Application no: **3/2023/0073**

Address: **61 Mellor Brow Mellor BB2 7EX**

Proposal: **Proposed single-storey rear extension, replacement of existing external cladding, proposed car port, porch alterations and change of windows.**

The Local Highway Authority have viewed the plans and highway related documents and have the following comments to make:

6739 - P01

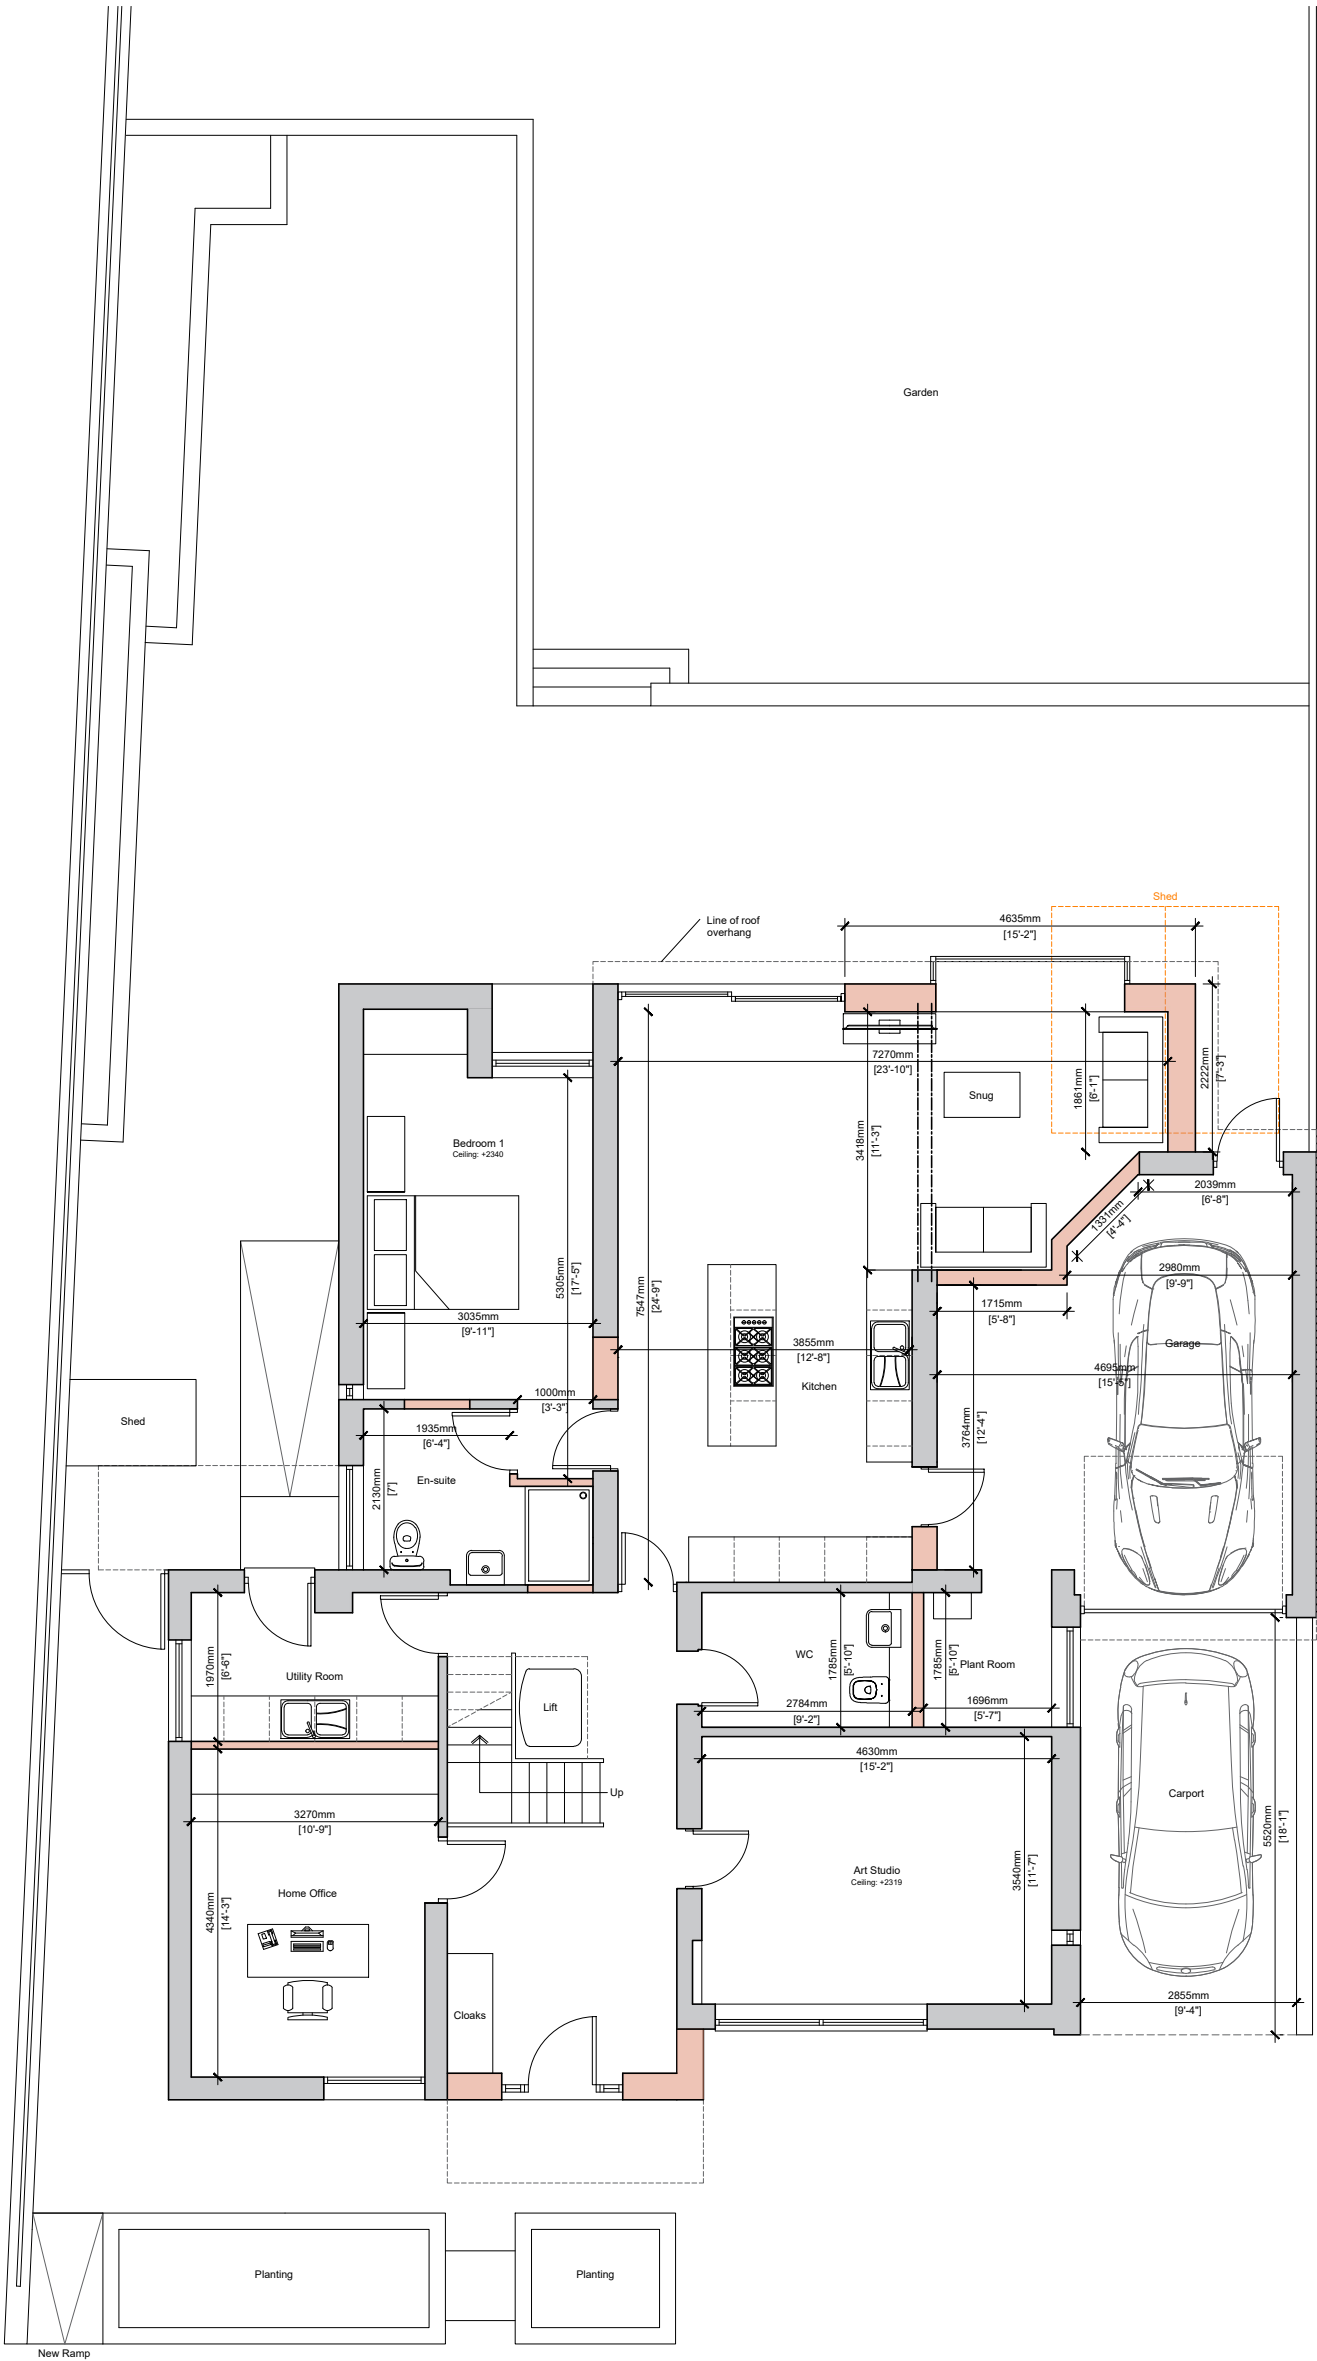
The LHA have reviewed the supporting documents and understands that the existing and proposed dwelling could potentially have 4 bedrooms should one of the additional rooms be converted. For the site to comply with the LHAs parking guidance as defined in the Joint Lancashire Structure Plan, the LHA require a minimum of 3 car parking spaces to be provided at the site.

The LHA have reviewed SPA drawing number 6739-P01 titled "Proposed Ground Floor Site Plan," the Applicants further information dated 10th March 2023 and Mapzone and are aware that a minimum of 3 car parking spaces can be provided at the site, with two being provided on the driveway and one in the carport. Since this complies with the LHAs guidance, the LHA have no objection to the proposal.

1. Prior to completion the parking and turning facilities should have been implemented in accordance with SPA drawing number 6739-P01. Thereafter the onsite parking provision shall be so maintained in perpetuity.
